SYD12/00469
MP11_0015
Xi Lin (AP)
8849 2906

Transport
Roads & Maritime
Services

**EXHIBITION OF PROJECT APPLICATION FOR ROZELLE VILLAGE/BALMAIN
LEAGUES DEVELOPMENT OFF VICTORIA ROAD, ROZELLE**

Figure 2 – Modelled Site Access Arrangements

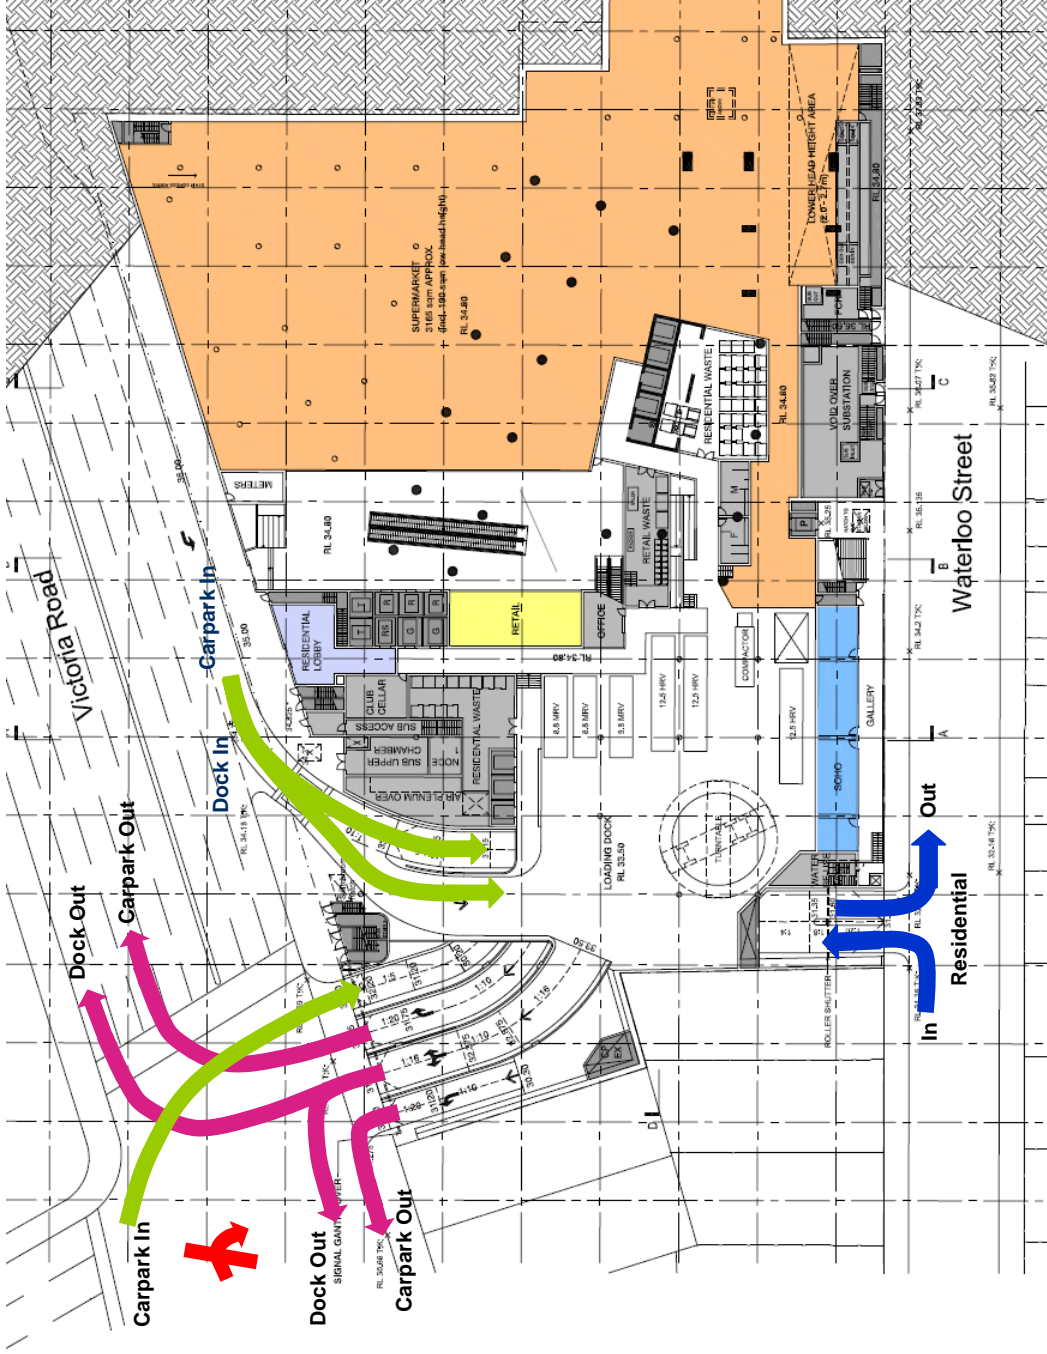
The proposed fourth leg to the existing signalised T intersection at Victoria Road / Wellington Street will increase bus travel times on the Inner West Busway and increase vehicle queues along this section of Victoria Road. This signalised intersection currently operates with two phases. Adding an additional leg to this intersection with left and right turn movements requires a third phase to be implemented, which takes away existing green time allocated for buses and motorists on Victoria Road.

Further to the above, as part of the proposed modified signalised intersection on Victoria Road, the stop line for westbound traffic would need to be relocated further East which would result in longer intergreen times which would also subsequently add further delay to buses and motorists on Victoria Road.

- A through movement from Wellington Street into the subject development and the banning of all other movements to/from the proposed development via this signalised intersection. If the applicant is to pursue this access arrangement further, Council shall be consulted as Wellington Street is under the care and control of Council.
- A left-in/left-out access arrangement on Victoria Road on approach to the existing signalised intersection on Victoria Road at Wellington Street. This is subject to the construction of a left turn deceleration lane designed and constructed in accordance with Austroads and sufficient land dedication as public road to maintain existing footpath widths.

Note: The left-out access should be located as far as possible to the East of the Victoria Road / Wellington Street intersection.
